## Wicklow County Council

RE: Referral Ref. ABP 320327-24

I refer to your letter of the 06/08/24 in relation to the above mentioned Referral. The Planning Authority considers that its reasons and considerations in relation to the submitted S5 Declaration Request are fully set out in its planning report and Declaration previously forwarded to the Board. However, the Planning Authority would like, in the interests of clarification, to comment on the submitted Referral as follows.

JOB TITLE	Development at Kippure Estate	
CLIENT	Tondo Ltd.	DATE
LOCATION	Manor Kilbride, Blessington, Co. Wicklow.	14/02/24
SDSUS	APPROVED	SCALE
DRAWN	APPROVED	1:100 @ A3
BORNING No.	Structure No. 1	REVISION
PL1081KE	Gate Lodge A.

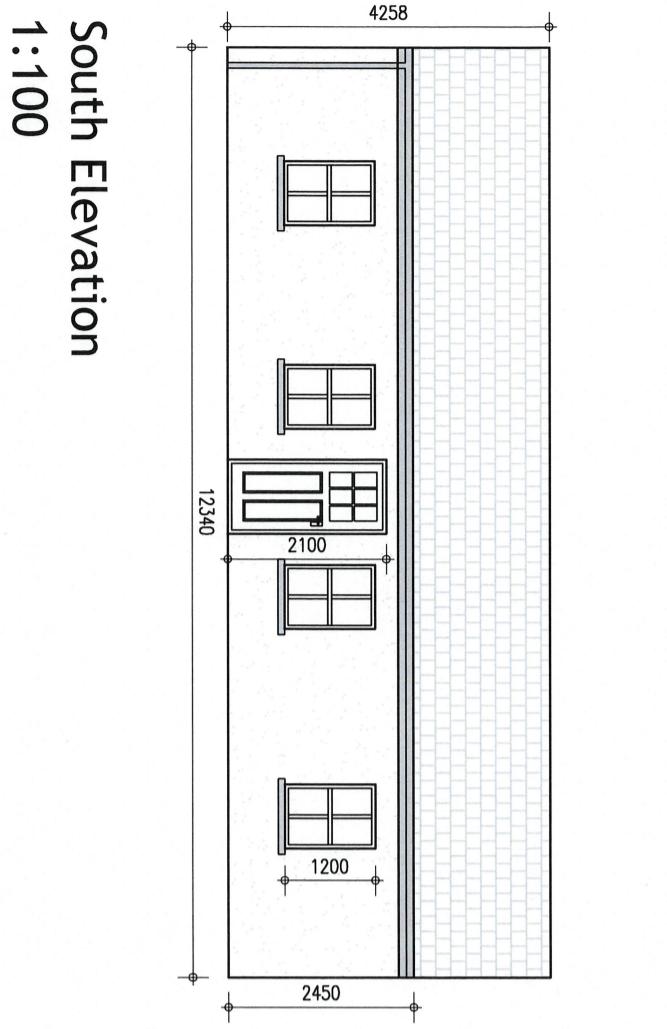
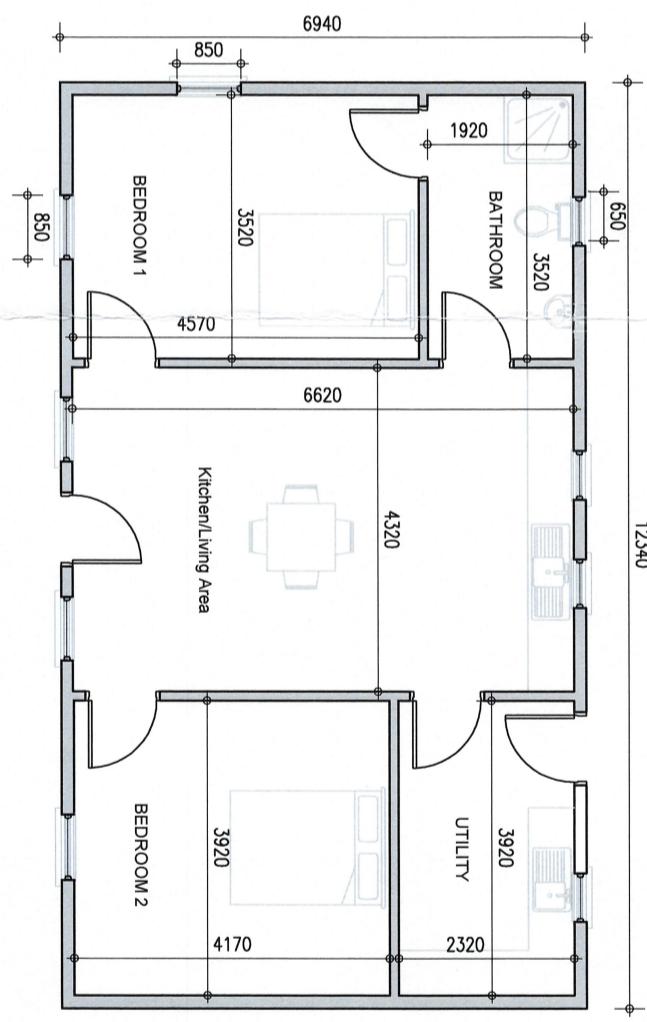
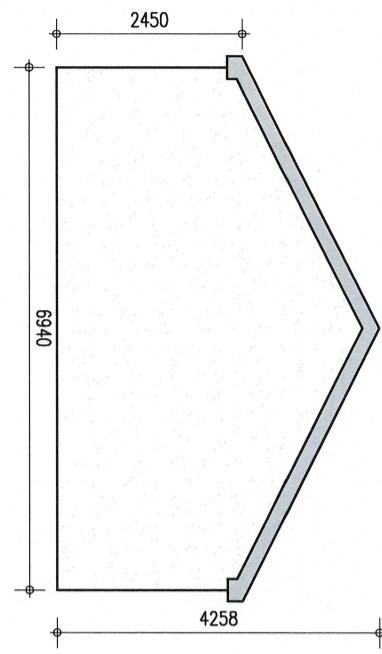
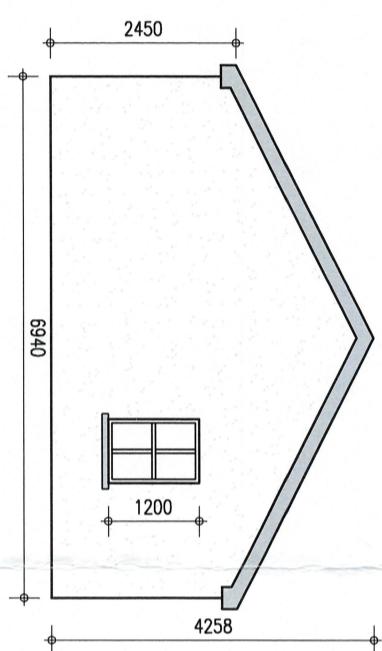
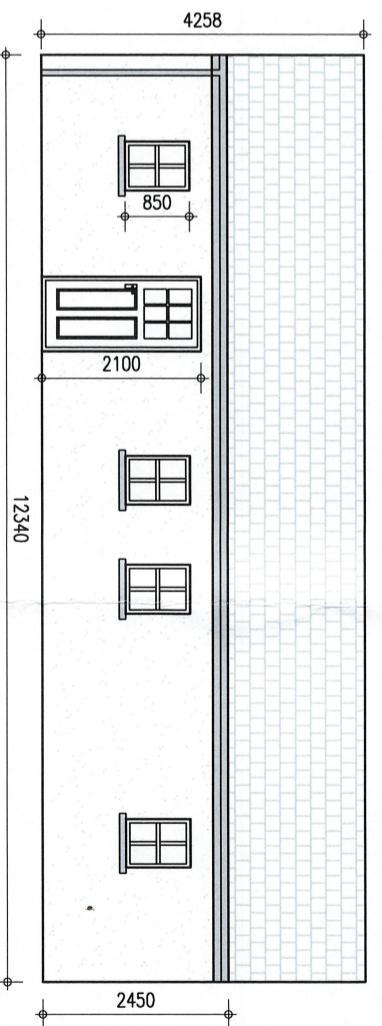
Class 17 is for persons who are employed, or otherwise engaged, in connection with the carrying out of the development, during the period in which it is being carried out. Class 17 also comes under the heading in Schedule 2 of "Temporary structures and uses".

The rationale set out in the Referral for Class 17 being applicable to those employed in the operation of the development does not make sense. Expanding the meaning of "the carrying out of the development" to include the operation of the development, not only would represent a misunderstanding as to what is meant by/the scope of "the carrying out of the development", it would also, if accepted, have the effect of using a class of exemption for temporary structures and uses for non-temporary/permanent uses.
